**Subject: Environmental Impact Statement – Mamre Road Data Centre Campus
(SSD - 92743706) (Penrith)**

CPHR comments on the Environmental Impact Statement – Mamre Road Data Centre Campus (SSD-92743706)

Figure 11: Post-development MUSIC model layout – Phase 4

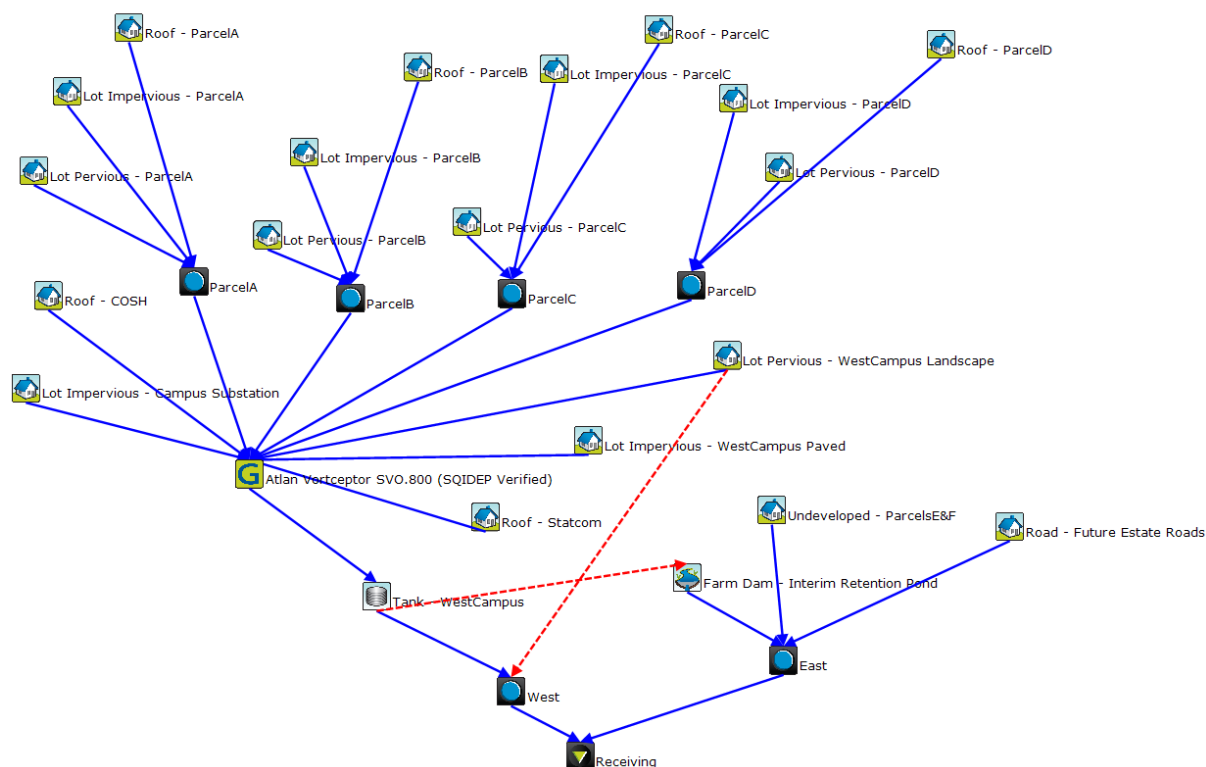
9.	<i>MUSIC Model</i>	The Water and Stormwater Management Plan (WSMP) includes the proposed stormwater strategy and references the MUSIC model. However, CPHR advises that the MUSIC model was not provided. CPHR requires the MUSIC model to verify compliance with waterway health targets detailed in Technical guidance for achieving Wianamatta-South Creek stormwater management targets (Technical Guide). Recommended action: Provide MUSIC modelling to support the proposed stormwater strategy.
	<i>Extent and Timing</i>	Response to Submissions

Project name: <b>MAMRE ROAD DATA CENTRE CAMPUS</b>
Drawing title: <b>SEDIMENT AND EROSION CONTROL PLAN SHEET 2</b>
Drawing Number: <b>SYD4-SITE-DRG-ATL-CIV-02202</b>
Rev: <b>01</b>

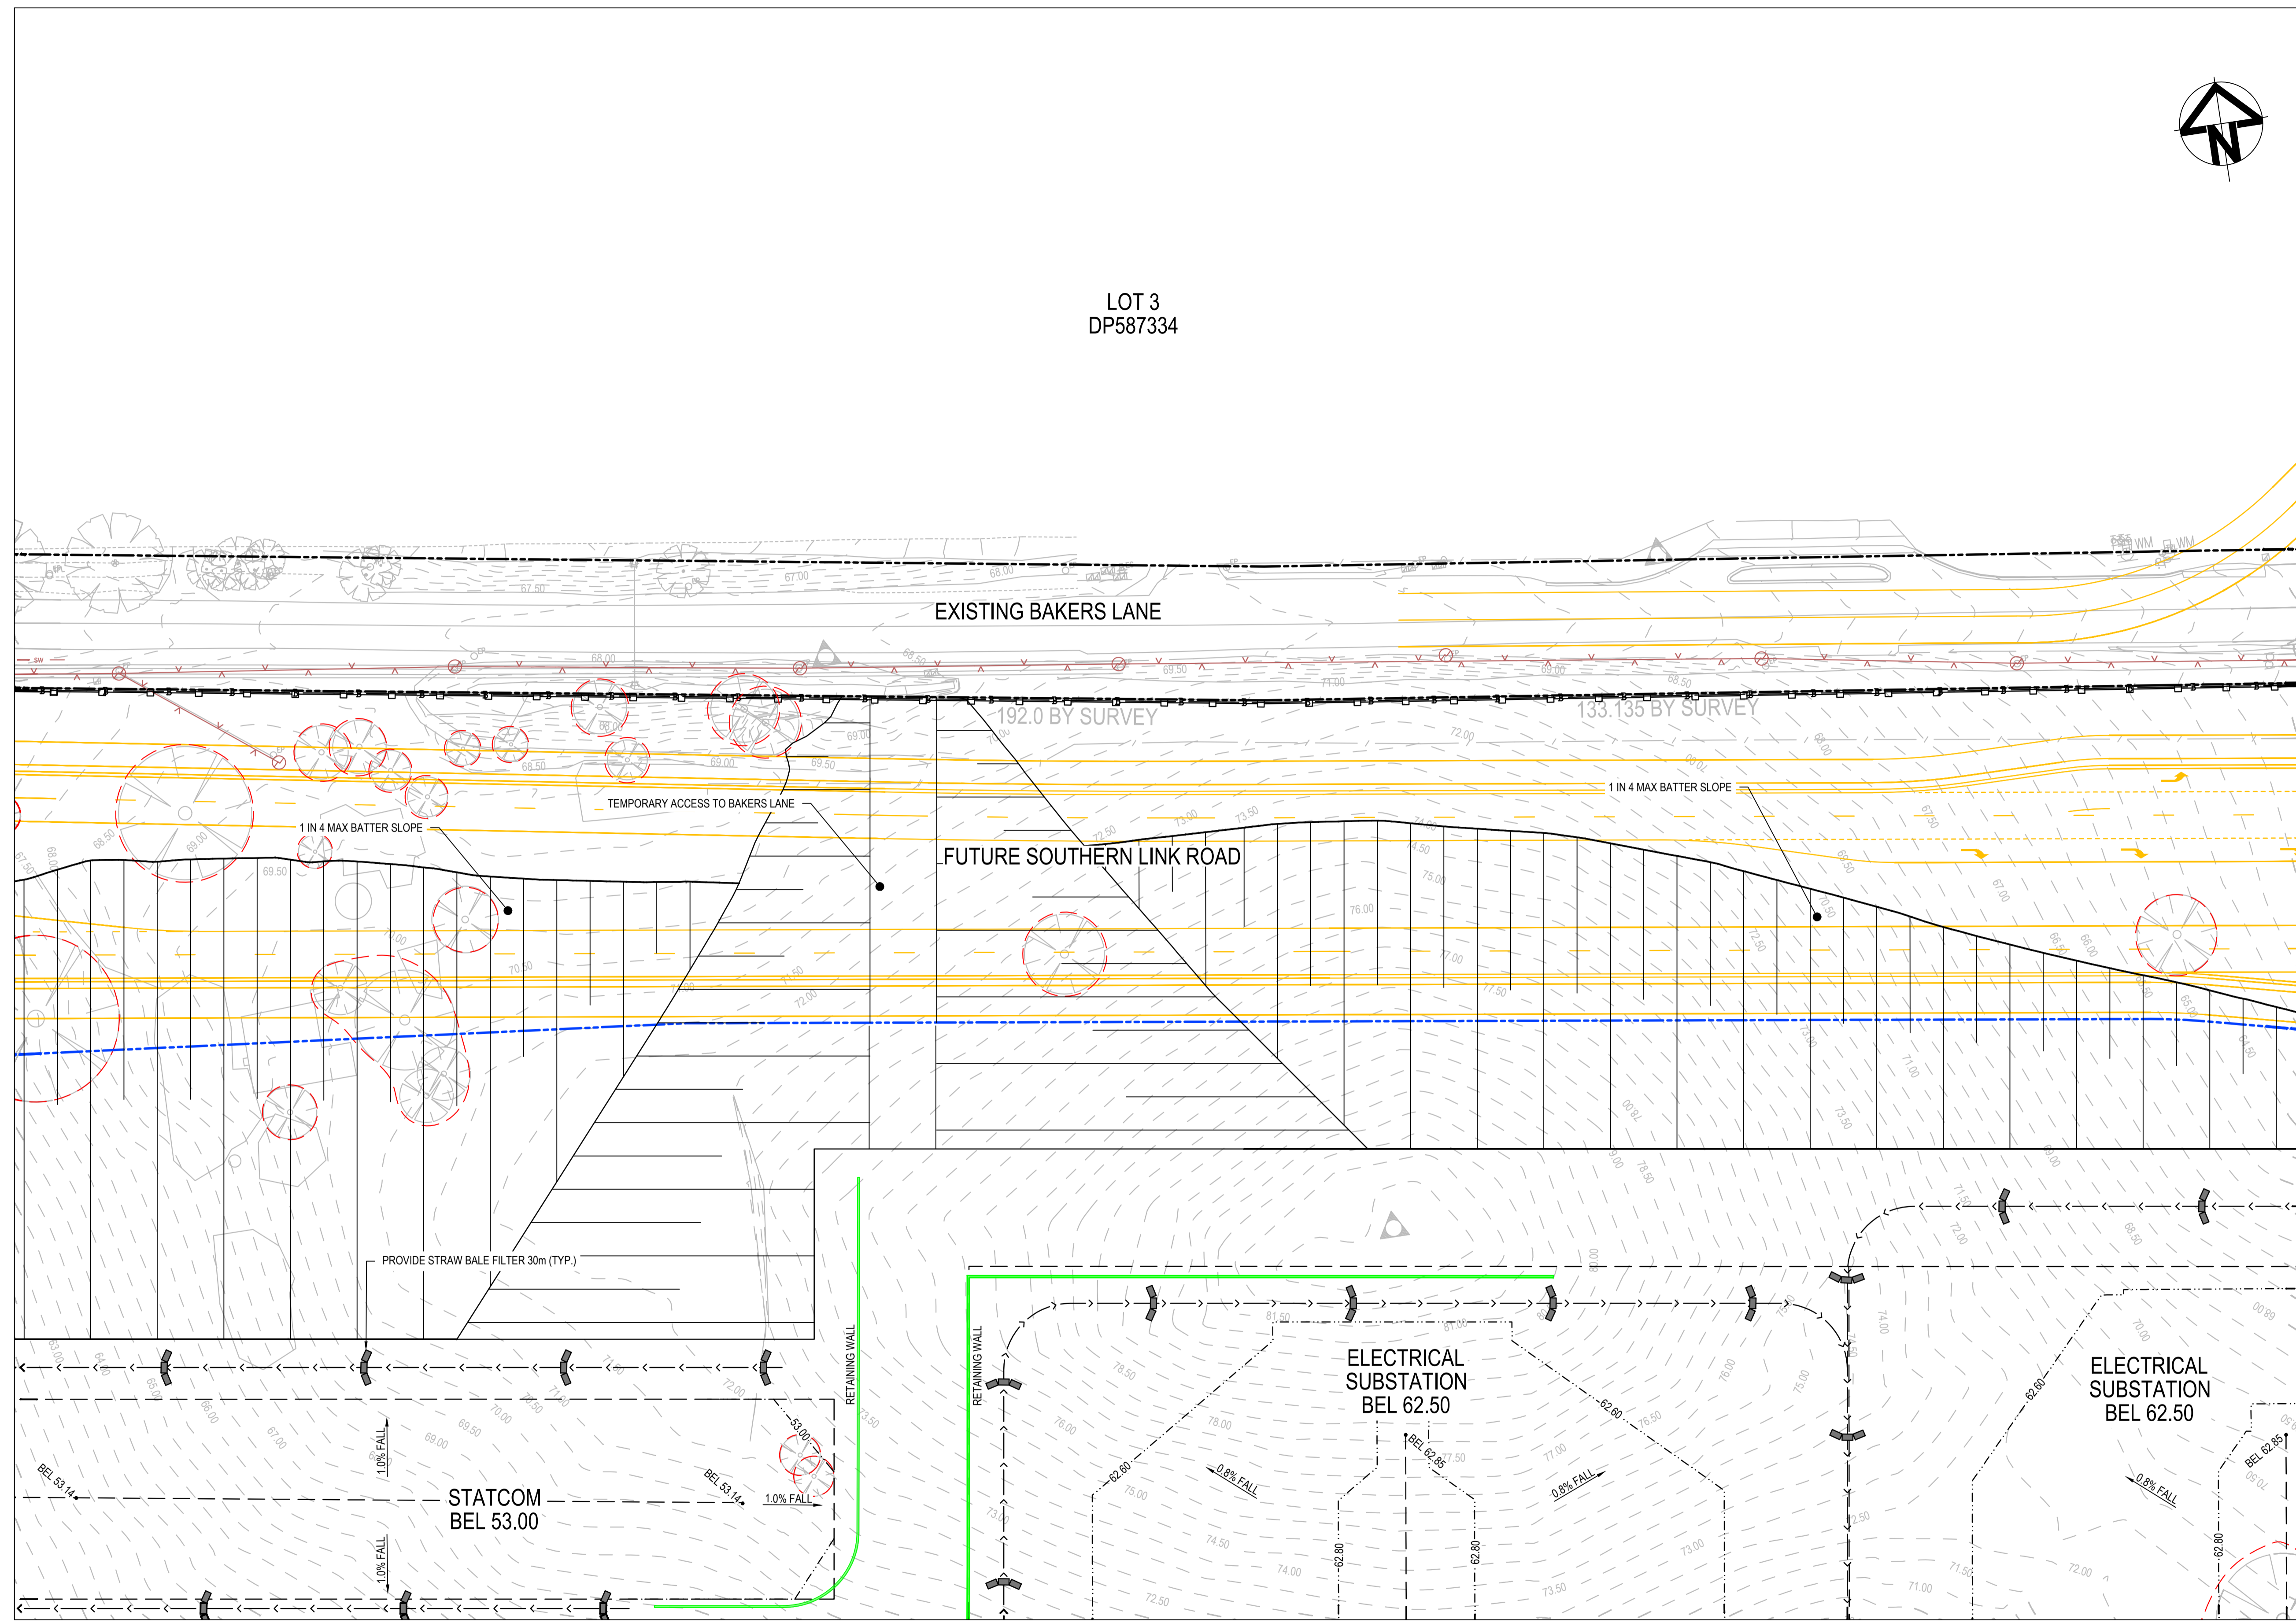
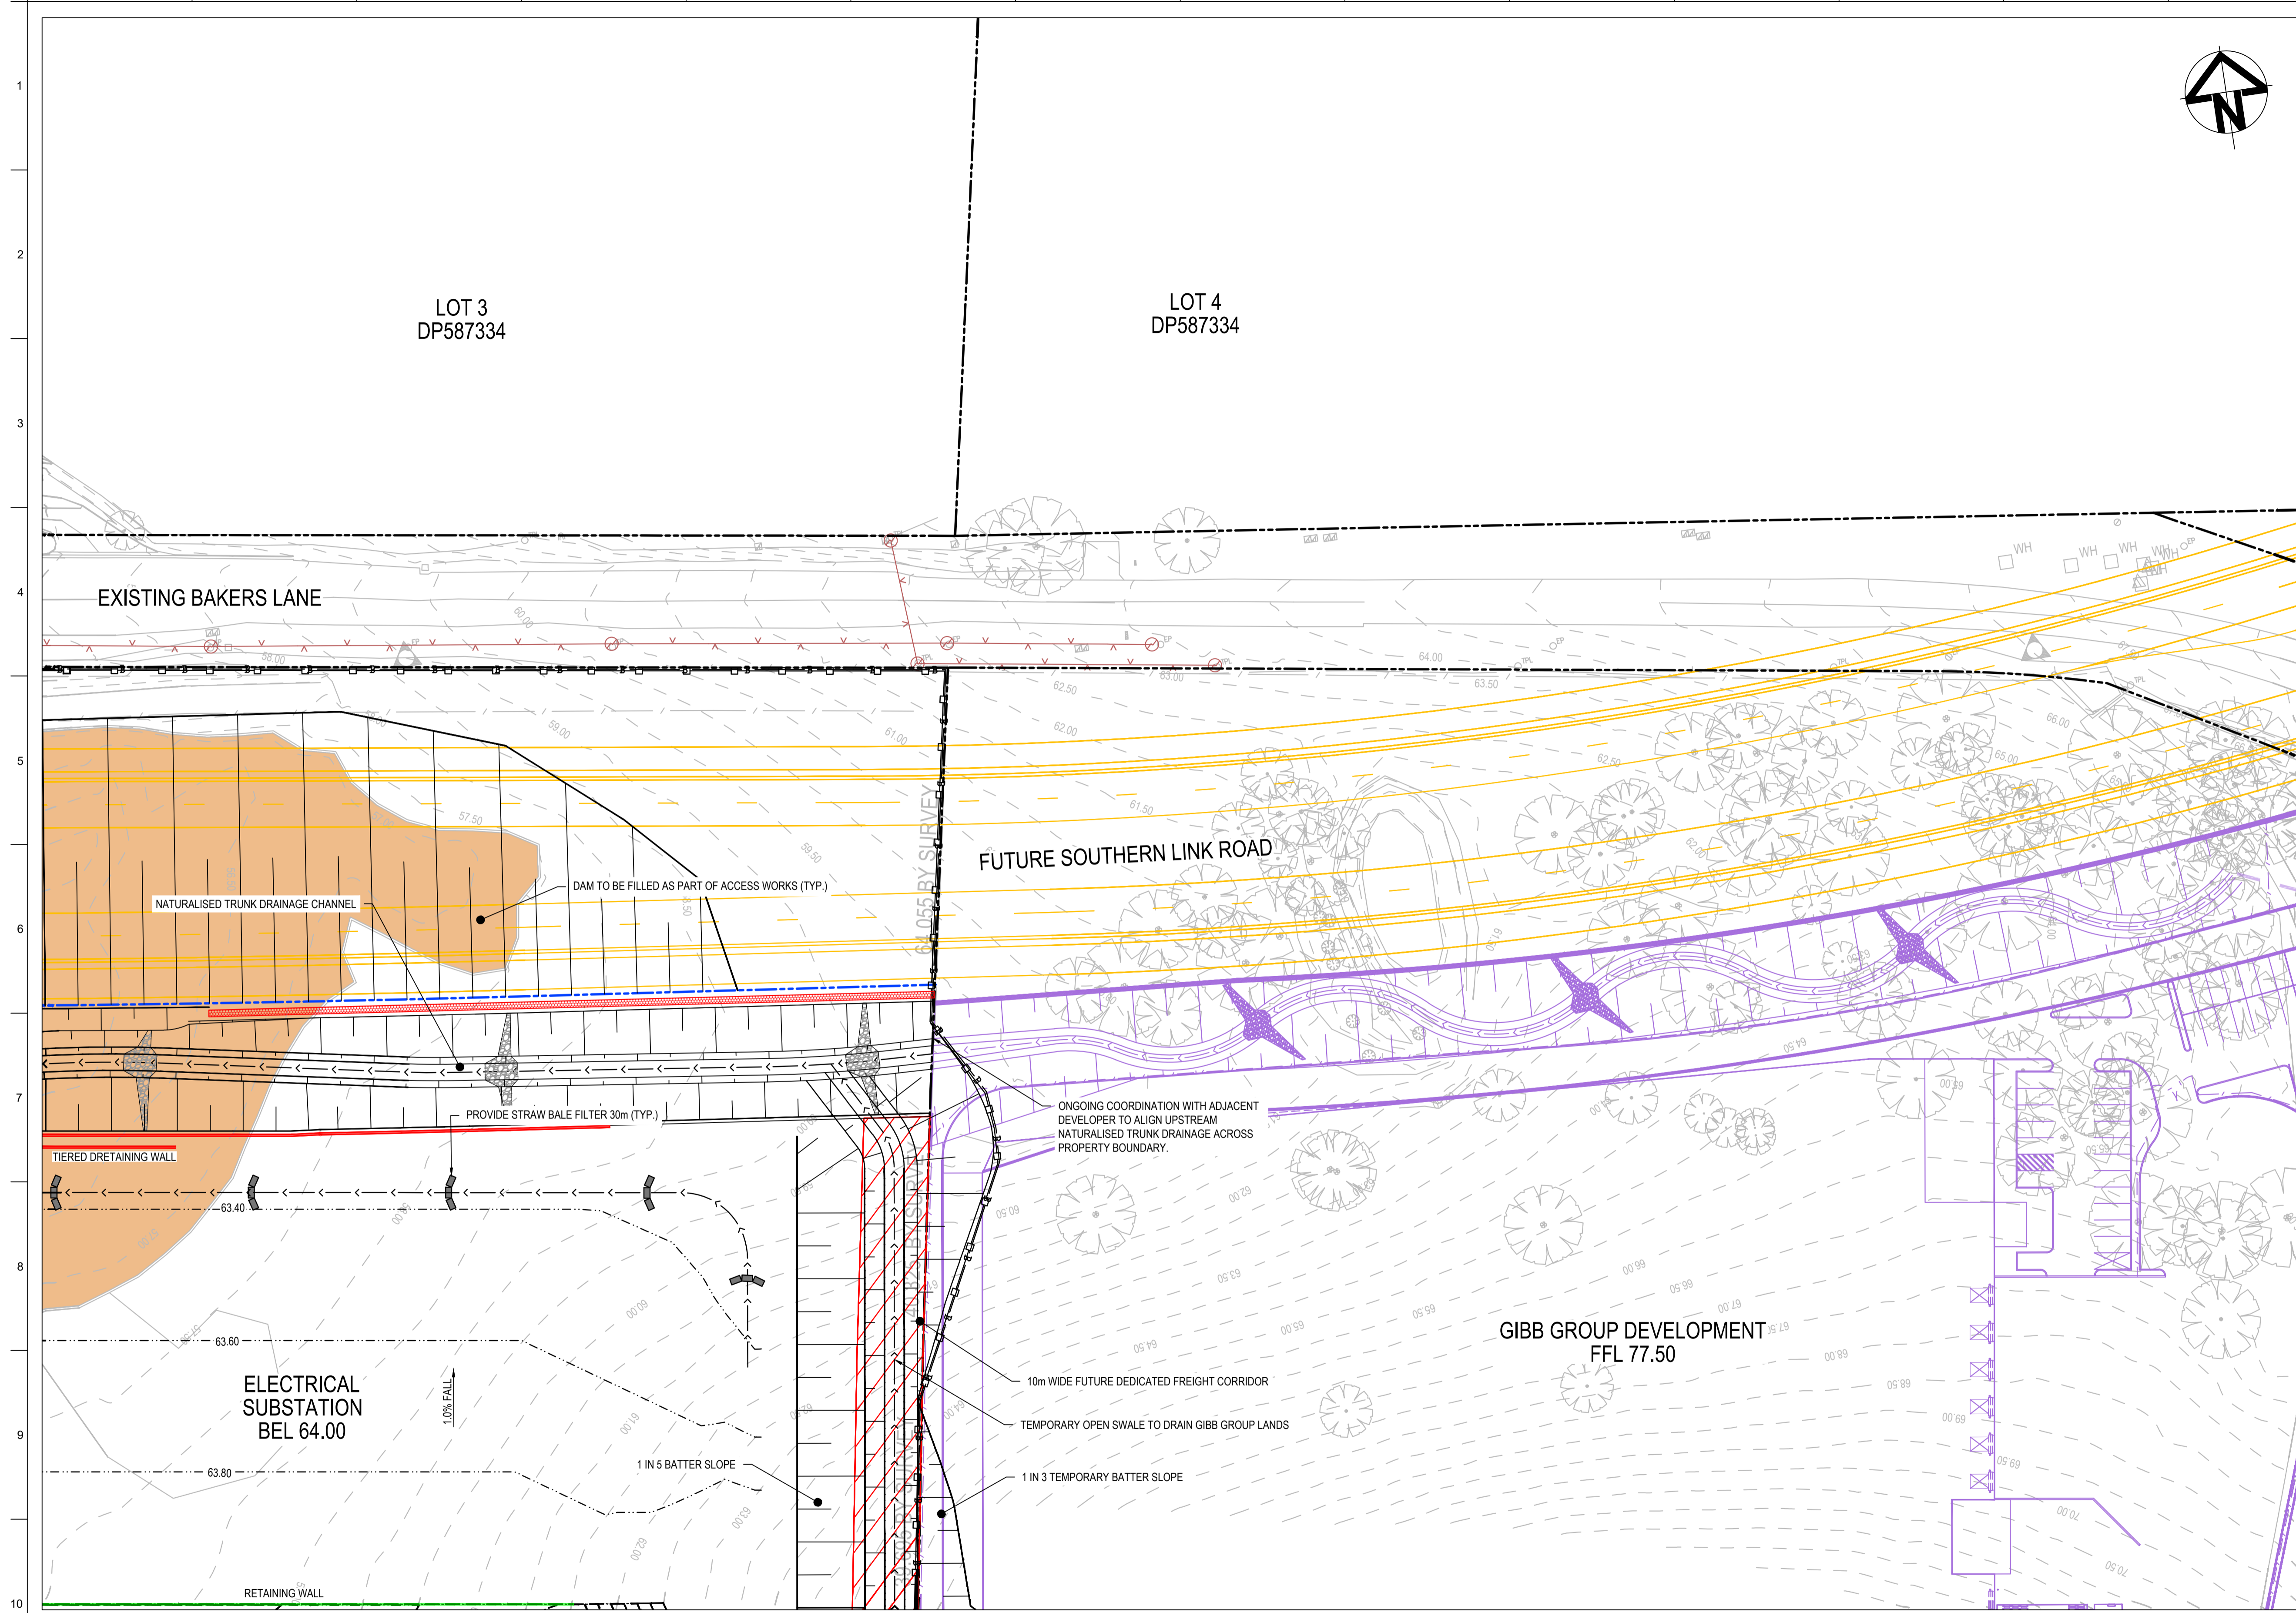
11.	<i>Erosion and Sediment Control Plan (ESCP)</i>	CPHR advises that the ESCP has inadequate details for each construction phase to understand the proposed stormwater strategy. The proposed erosion and sediment control details for all interim phases was also not provided or included in Civil Drawings. For each construction phase a civil drawing with the proposed ESCP measures should be provided. CPHR advises the applicant refer to 805 Mamre Road (SSD-30871587) ESCP as a good example.

Recommended actions: • To demonstrate the construction phase stormwater quality targets are met, a detailed ESCP must: ○ be developed and certified by a Certified Professional in Erosion and Sediment Control, or a qualified and experienced civil engineer with at least 5 years' experience in the development of site-specific soil and water management plans ○ be prepared in accordance with the Blue Book (NSW Government 2004) and water sensitive urban design (WSUD) considerations set out in Chapter 3 of the Technical Guide ○ provide conceptual designs that include the site, catchment and key features of erosion and sediment controls on scaled drawings ○ illustrate appropriate controls, that when implemented will achieve the construction phase stormwater quality targets in Table 2 of the Technical Guide. • As the subject land is larger than 2,500m², the Technical Guide provides best practice initiatives which strengthens requirements from the Blue Book. This involves designing and implementing sediment controls that treat at least 80% of the average annual runoff volume (i.e. 80% hydrological effectiveness) to 50 mg/L total suspended solids (TSS) or less, and pH in the range 6.5–8.5. To achieve these construction phase targets, the design of the basins generally needs to: ○ be sized and operated in accordance with either a Type-A or Type-B sediment basin as documented in <i>Best Practice Erosion and Sediment Control</i> (International Erosion Control Association (IECA), 2008) ○ be provided with an automated system of flocculant dosing and a suitable supply of flocculant/coagulant, with the type of flocculant/coagulant determined based on the <i>Chemical coagulants and flocculants fact sheet</i> (IECA 2018) ○ have markers within each basin to show the maximum sediment storage level and any additional water storage capacity for water reuse ○ limit discharge from the primary outlet system to 50 mg/L TSS, with a pH within the range of 6.5–8.5 ○ be operational before any disturbance occurs in the catchment upslope of the basin ○ if not using Type-A or Type-B sediment basins provide robust justification to demonstrate use of alternatives.
